Re; Flood Relief Works at Graiguenamanagh, Co. Kilkenny & Tinnahinch, Co. Carlow.

Report on DAU Observations to Part 10 Development (ACP- 323951-25)

Graiguenamanagh Tinnahinch Flood Relief Scheme

Report No. W3451-W-R022

DRAWING
TITLE
FLOOD RELIEF WORKS
SITE LAYOUT PLAN

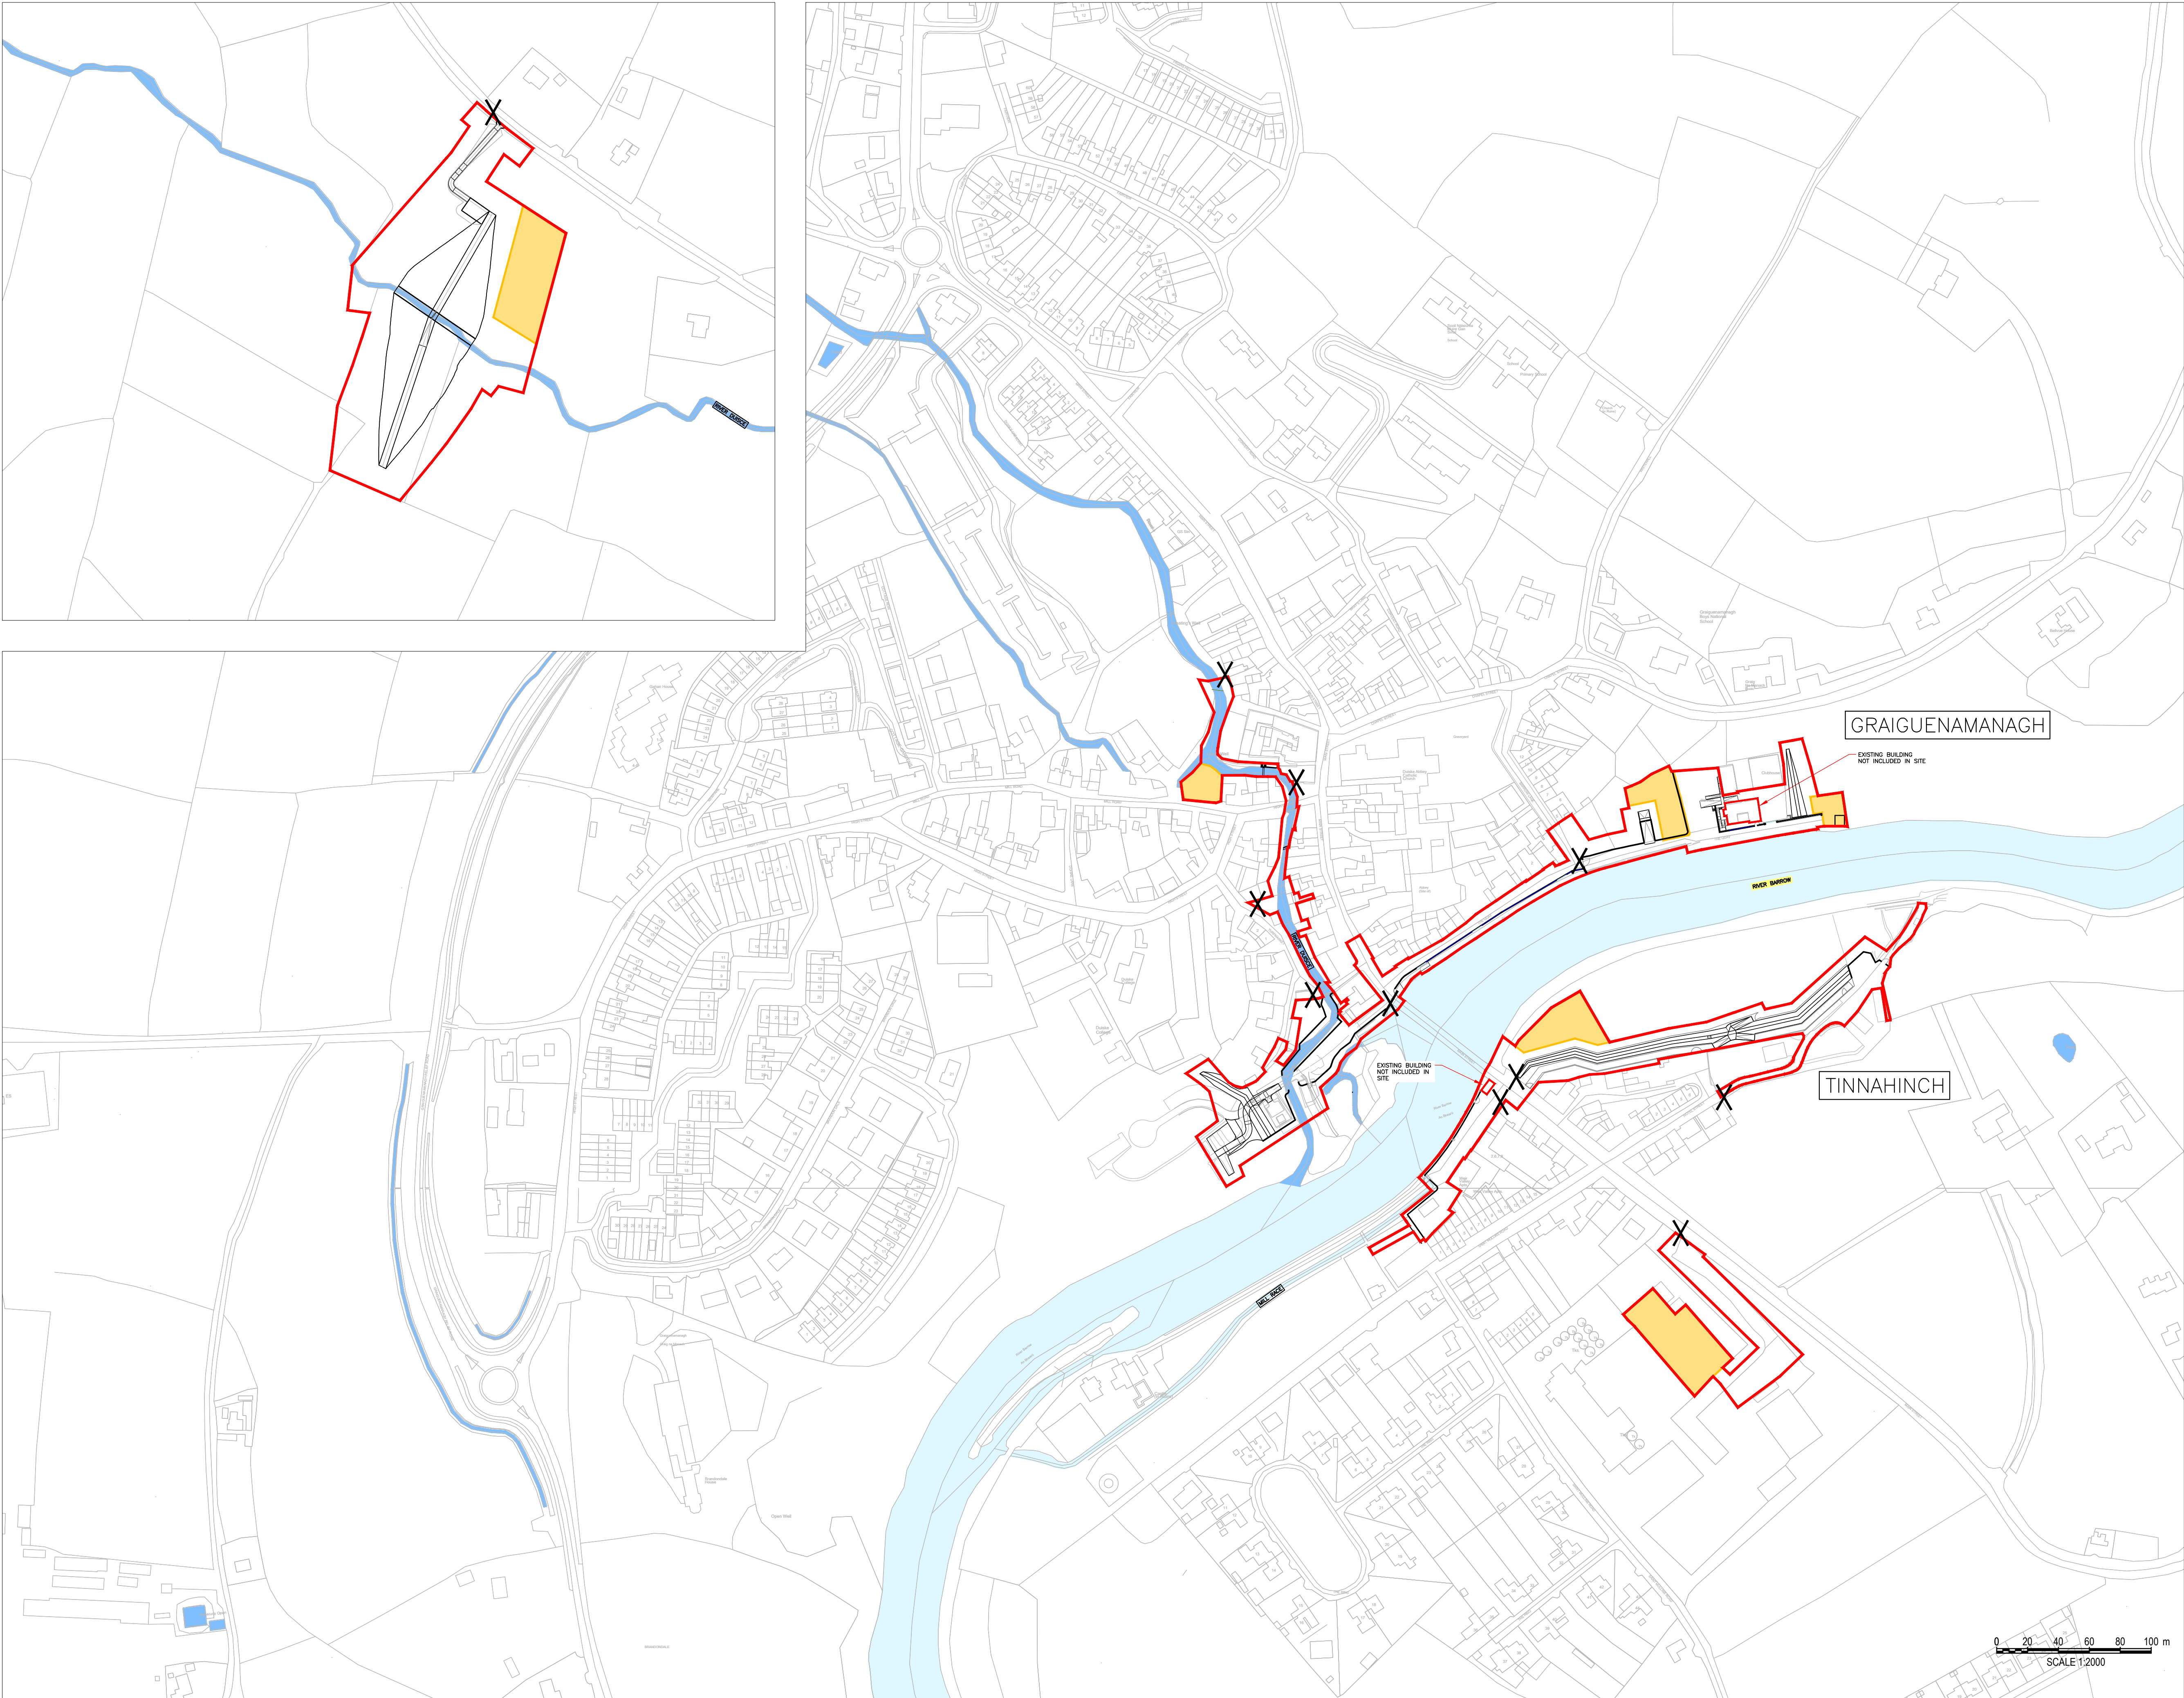
There are 6 compounds shown on Drawing no. W3451-AYE-DWG-W-1402. These include a main compound for use for the duration of the construction programme, and additional compounds for use for individual works packages. The main compound (SC-A) in Tinnahinch will serve as a base, where the site offices and welfare facilities will be located. No stockpiling of materials or equipment is

proposed at this location. This compound is more than 150m from the SAC. By the nature of the flood relief works, works areas are within or proximal to the river, meaning site compounds adjacent to the river are unavoidable. The remaining site compounds (SC-B - SC-F) have been sited largely on made ground and will not impact upon habitats for which the SAC is designated. These compounds will be maintained to the minimum size required and will have silt fences on the perimeter of the compounds to prevent any run-off into the SAC (as per mitigation measure Bio_2). Further, all materials will be banded or stored in the dry. The location of the compounds adjacent to the river are fixed to facilitate the construction at the various works areas, particularly for the storing of equipment. A minimum buffer of 3m has been applied to allow a natural bank path.

As detailed in Section 4.4.17 of the EIAR, rainwater run-off from the contractor's compounds will be controlled via a temporary surface water control system comprising measures such as swales (ditches) and settlement ponds (or similar system) which will minimise the risk of pollution to soil, surface water or groundwater. The temporary surface water control system will be subject to a visual inspection as well as routine maintenance. The inspection frequency will be increased during periods of exceptional high rainfall.

The management of surplus excavated material or temporarily stored materials at the site compounds will be determined by the classification of the material (i.e., contaminated, or not, in line with the European Waste Catalogue and Hazardous Waste List, the Waste Management Act and the Hazardous Waste List), which will be the responsibility of a dedicated Waste Manager in line with the mitigation measures WM_1-WM_5 outlined in Chapter 7 'Material Assets'.

Site compounds will be restored to their original state following the construction phase.
